From: Biazar, Shahab
Sent: Monday, January 11, 2016 11:26 AM
To: Yolanda Padilla Moyer; Chris Sholtis
Cc: Harmon Rita T. (rharmon@cabq.gov); Abiel X. Carrillo (acarrillo@cabq.gov); Elliott, Stanice (staniceelliott@cabq.gov)
Subject: DMP for Pulte @ Mirehaven Phase 2, N-2-D of the Watershed Subdivision (H09/D017E)

After reviewing the revised plans for the DMP for Pulte @ Mirehaven Phase 2, N-2-D of the Watershed Subdivision (H09/D017E) I have the following comments:

NOTE: ALL INLETS SINGLE GRATE TYPE 'A' OR 'C', EXCEPT INLET 4 IS A SINGLE GRATE TYPE 'D'

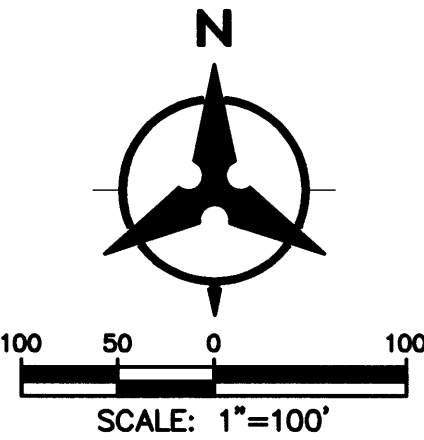
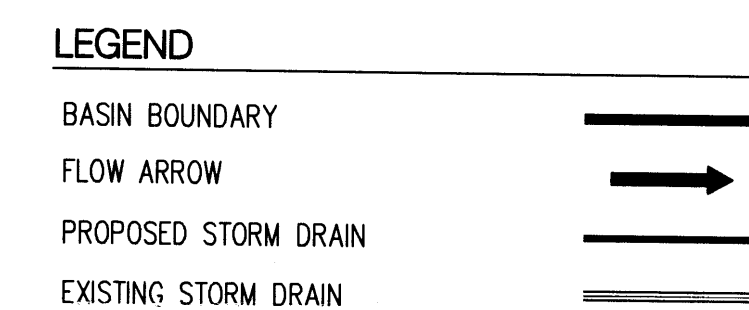
- Update storm drain map to reflect all the latest changes. Include the type of inlets (A or C) for each inlet. Provide all pipe sizes and capacity.
- Lots 6-20 drain to the back of the lots, to a swale and then to Abo Canyon Drive. The swale appear to go through an existing retaining wall. How does runoff get to Abo Canyon Drive? Does it drain over the wall and then over the sidewalk? It might be better to drain the runoff to the north to the pond and then to Abo Canyon Drive. Will there be sidewalk culvert?
- Section A-A shows a dimension of 7'-12' for the upper wall. Will the 7' be adequate for the swale or should it be 8' minimum? Is the 1" rock adequate size for the amount of runoff? Will there be a need for drop structures/erosion protection?
- If updating plans please keep all the dates the same for all the plans and the report.
